42 Esplanade Grande
The Esplanade
Bognor Regis
PO21 1NY

OBJECTION to BR/194/17/PL

I strongly object to Arun District Council's application to demolish the Foreshore office, decommission the underground toilets and put in replacement toilets facing my apartment.

SCALE 1 : 50	SHEET SIZE A3	DRAWN BY RC	CHECKED BY Nic	DATE 30/06/17
PROJECT NO. 3496	DRAWING NO. (08) 107	REVISION

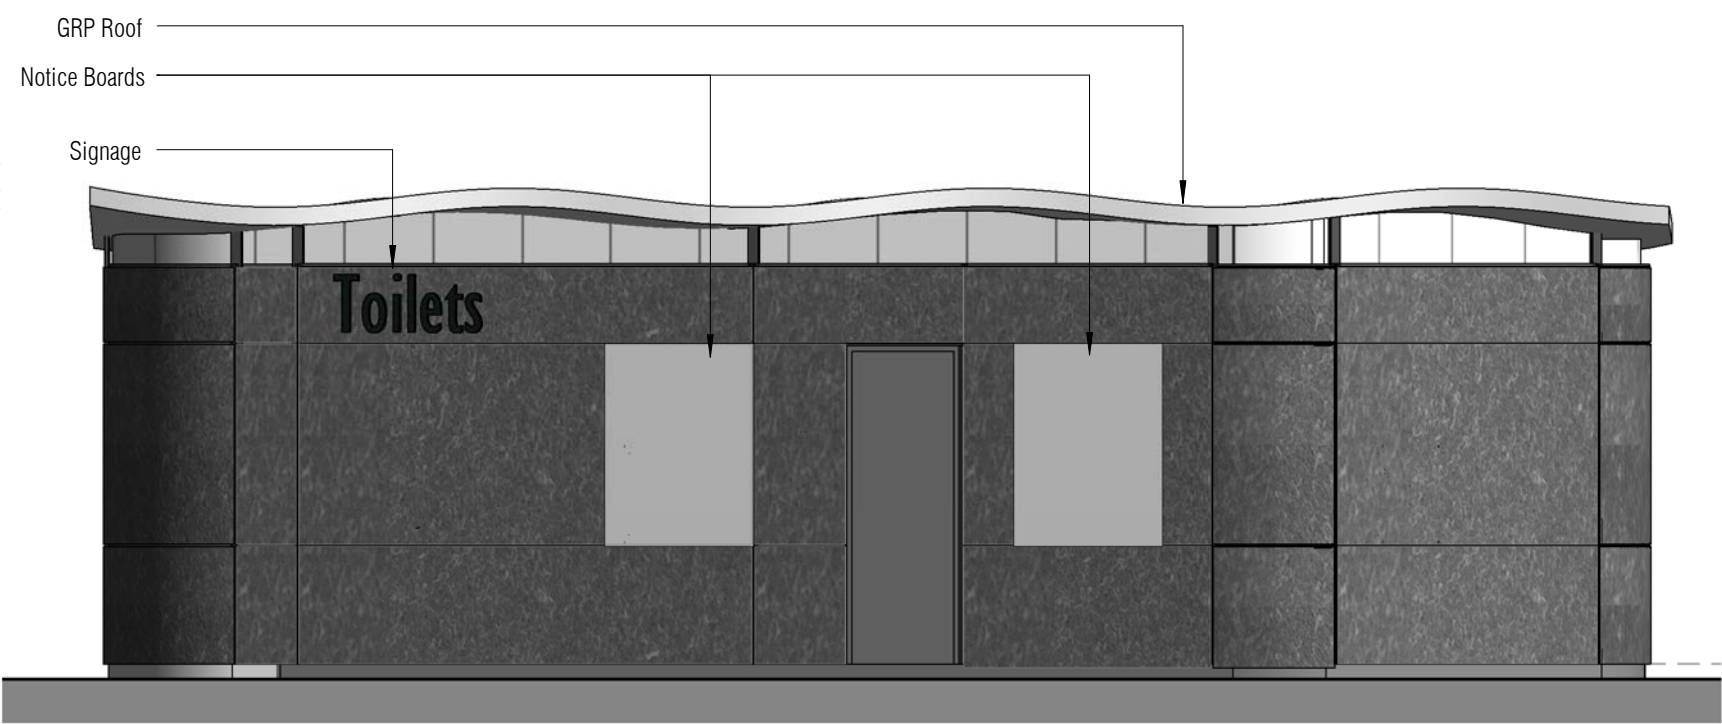
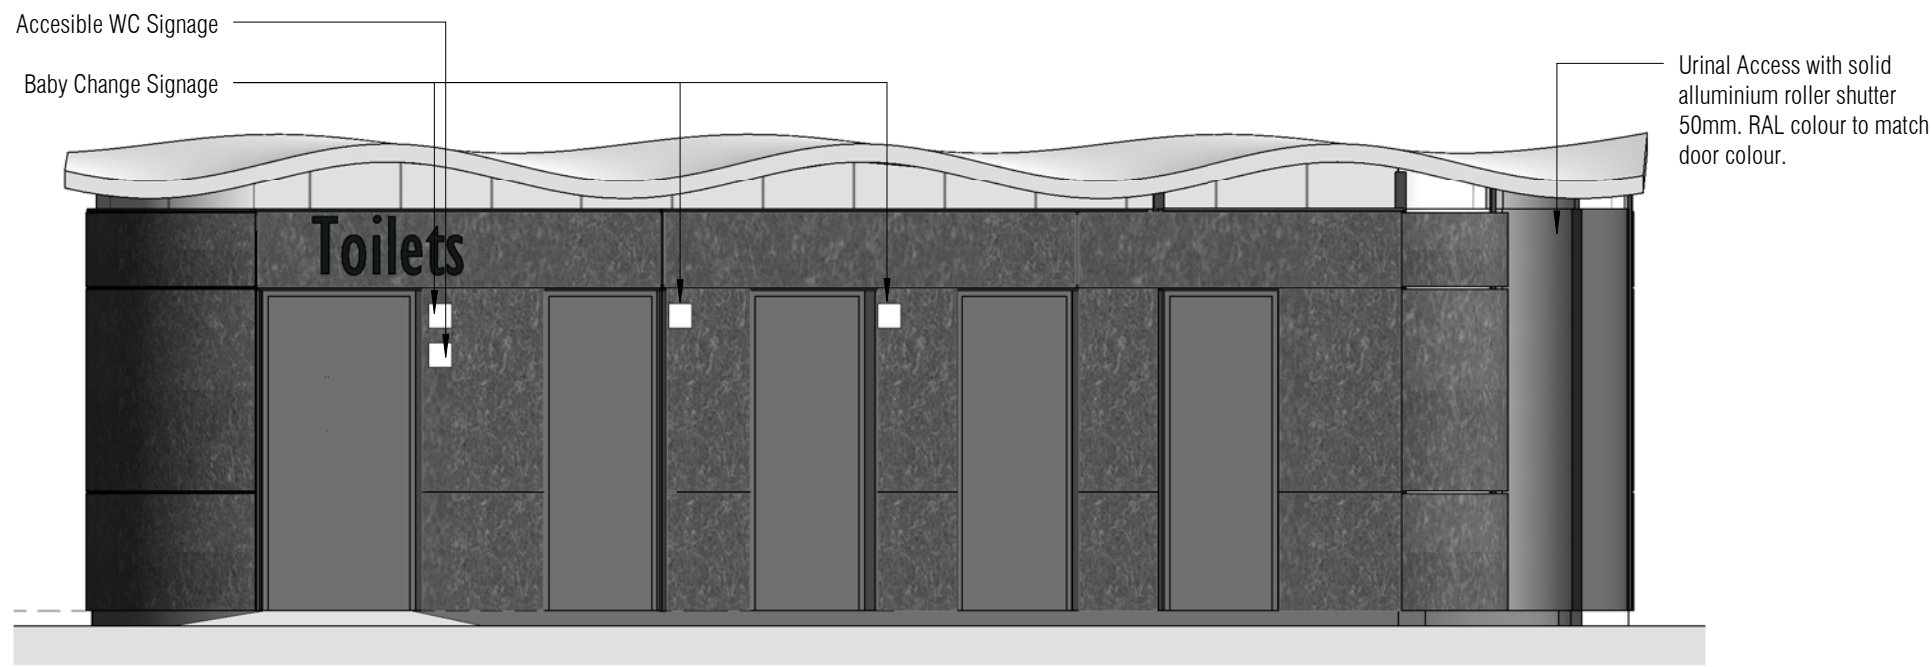
The proposed toilet doors and urinal entrance will be within 20m of my lounge window. This will be a dreadful infringement of my privacy as I cannot avoid that view.
